## **DRAFT STATEMENT OF COMMONALITY FOR STATEMENTS OF COMMON GROUND**

### **HyNet Carbon Dioxide Pipeline**

Document Reference Number D.7.2

Applicant: Liverpool Bay CCS Limited

DRAWING TITLE
**WORKS PLAN REGULATION 5(2)(i)
APPLICATION DOCUMENT
REFERENCE D.2.4
SHEET 19 OF 37**

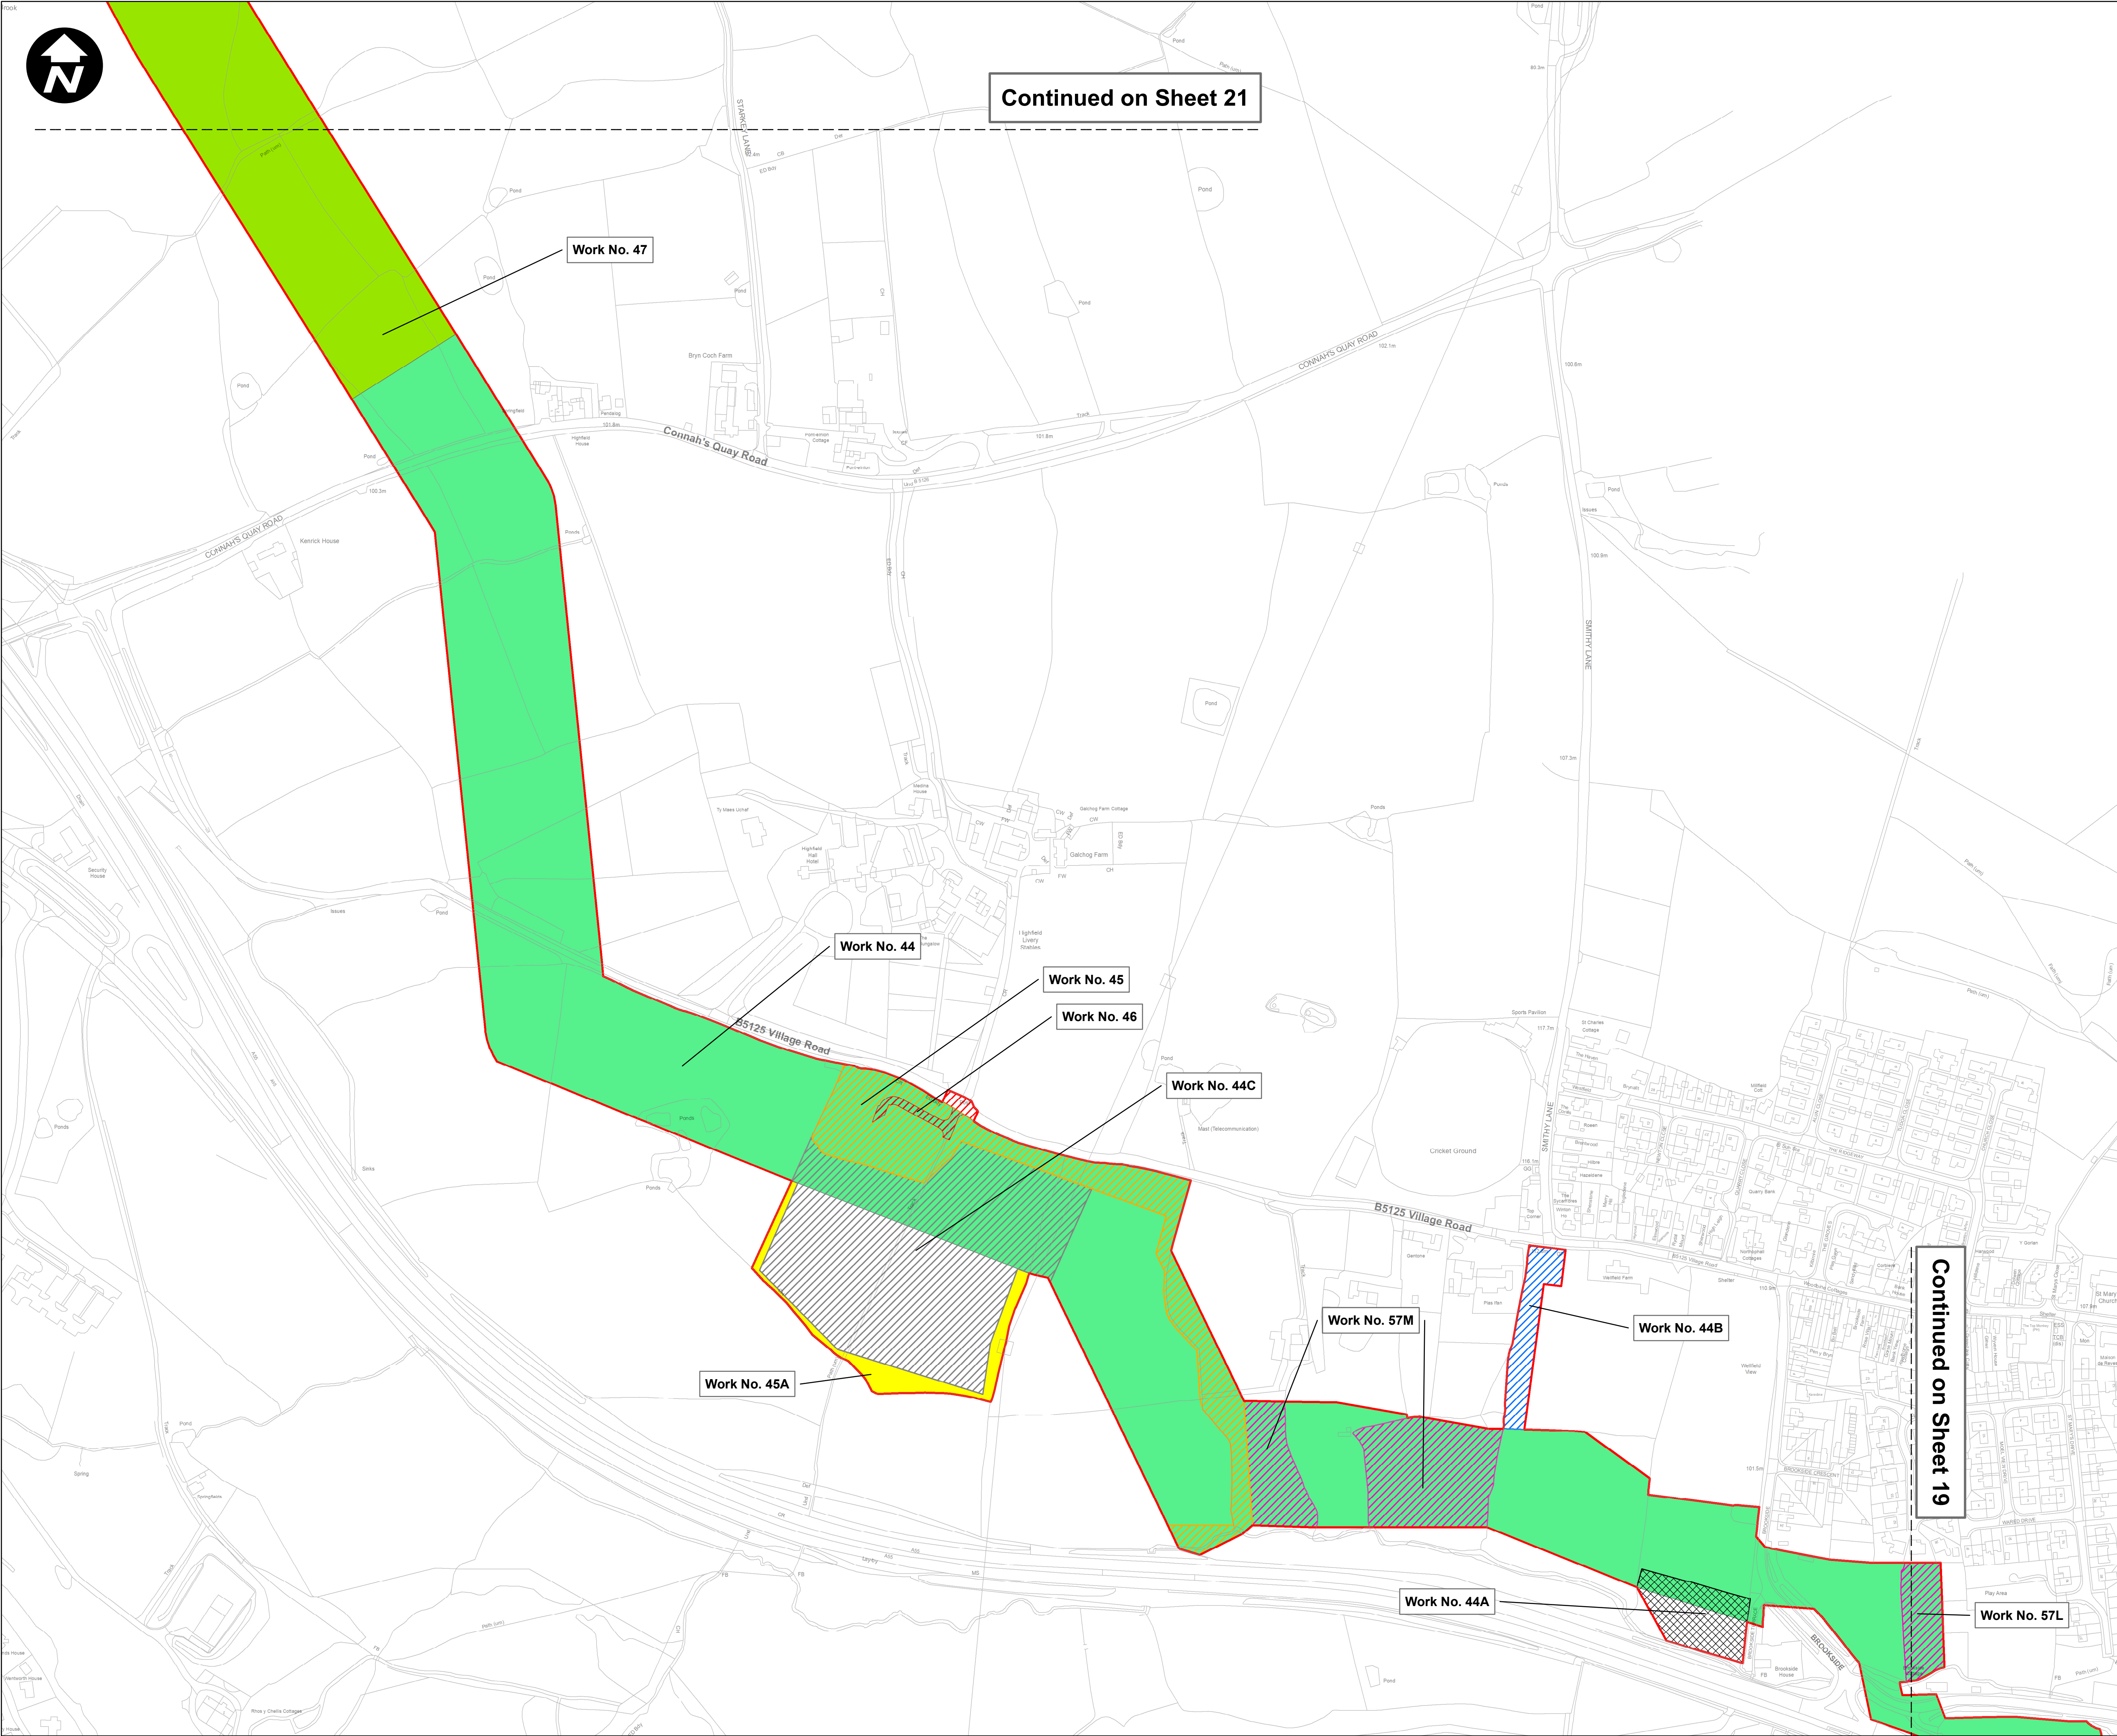
**SHEET 19 of 37** - WORKS PLAN REGULATION 5(2)(i) APPLICATION DOCUMENT REFERENCE D.2.4 Specific area: Works No. 57K, 43B, 43A and 57J [Identified as Alltami Brook: Section 5.0 of the CMRA]

Our records indicate that there are six mine entries (three on-site mine adits CA ref: 327367-053, 327367-048 and 327367-049) and three off-site adits CA ref: 327366-235, 327366-235 and 327367-234); recorded shallow coal mining; and a coal seam of workable thickness outcrops at or close to the site that may also have been worked at shallow depths. These mining features are present within the area to the west and east of Pinfold Lane and north of Magazine Lane, Ewloe.

The CMRA identifies the two mine adits and comments that a geophysics survey was carried out to confirm the presence of these features. The report author states that no indication of the mine adits were found, although a potential void was located in the north eastern corner of the field. However it is noted that due to sight constraints, a full survey was not completed.

DRAWING NUMBER
EN070007-D.2.4-WP-Sheet 36

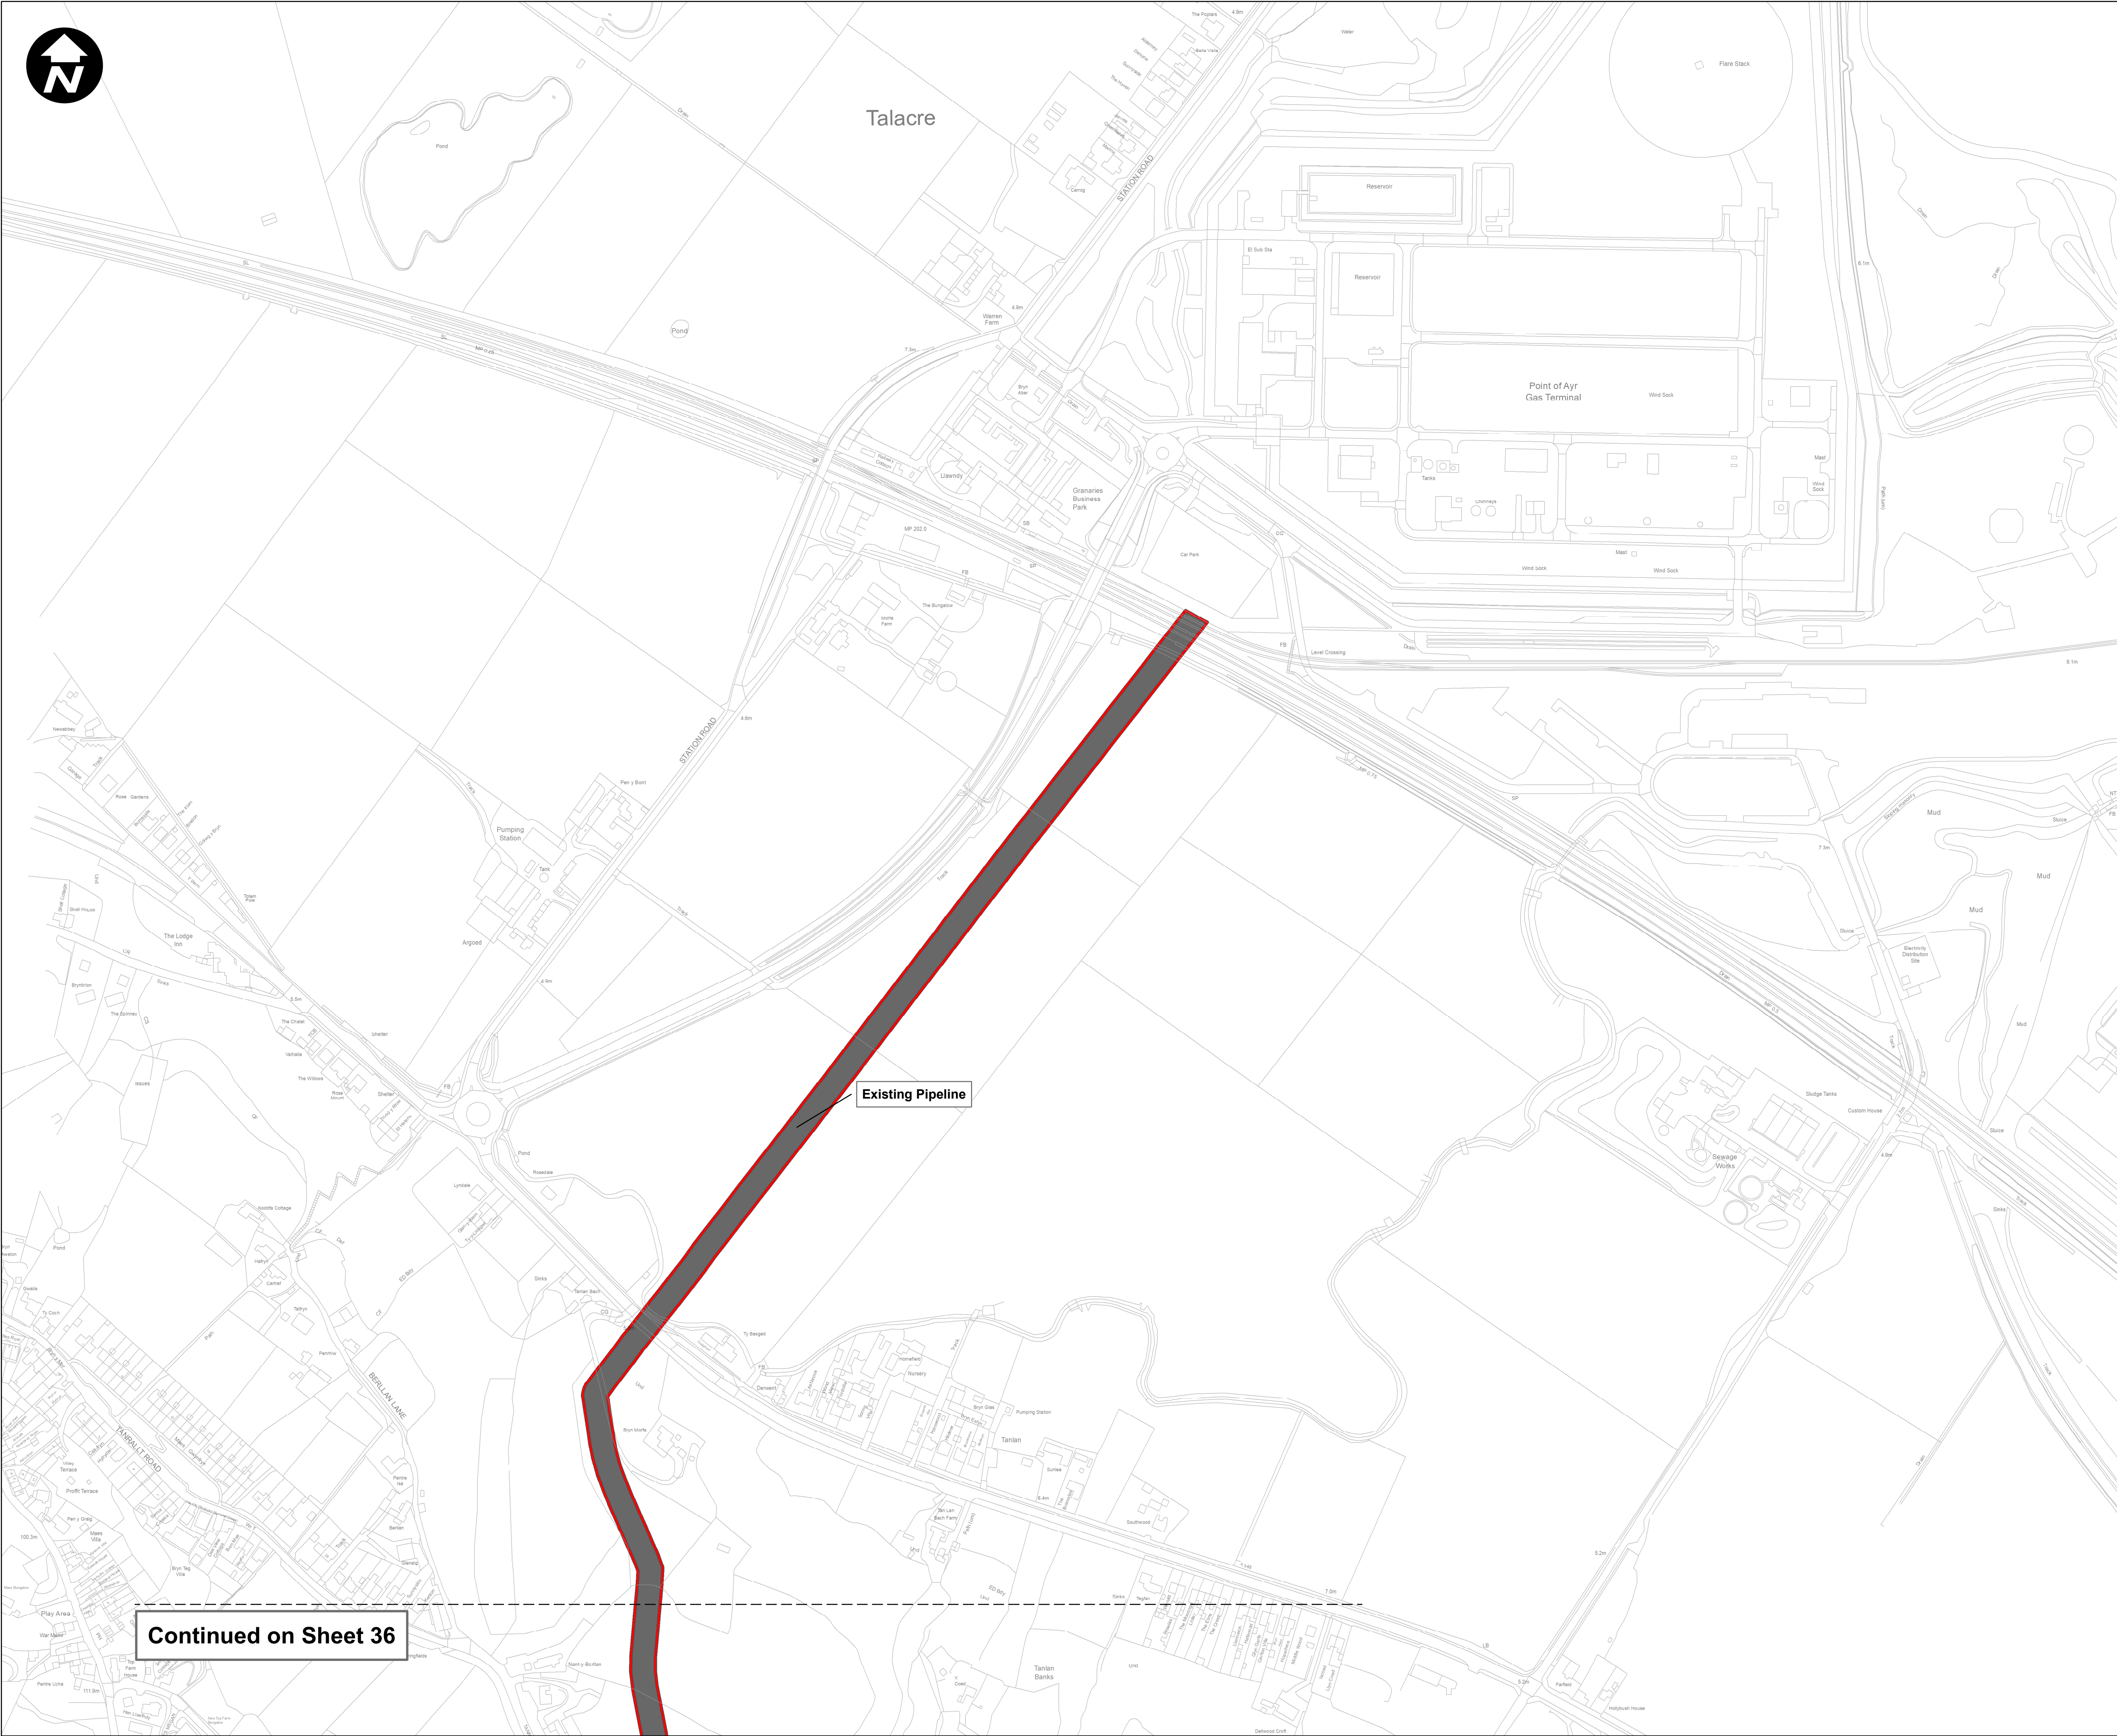
**SHEET 36 and 37 of 37** - WORKS PLAN REGULATION 5(2)(i) APPLICATION DOCUMENT REFERENCE D.2.4 Specific area: Existing Pipeline[Identified as Point of Ayr Section 4.2 of the CMRA]

Our records indicate that the zone of influence of a recorded mine entry (CA shaft ref: 311382-011) extends into the red line boundary and the site lies within an area of probable shallow coal mine workings.

The CMRA states that the site does not lie within an area of probable historic unrecorded shallow coal mining however there are two recorded mine entries within the site. The Report makes reference to Coal Mining Report ref: 51002948750001, however I have not been able to find this specific Report in Appendix B. Nevertheless, it is acknowledged that this part of the project is the existing pipeline, which is to be decommissioned and then commissioned with a new plant (temporary storage compound). It therefore appears that no changes or new development is being proposed in this area.
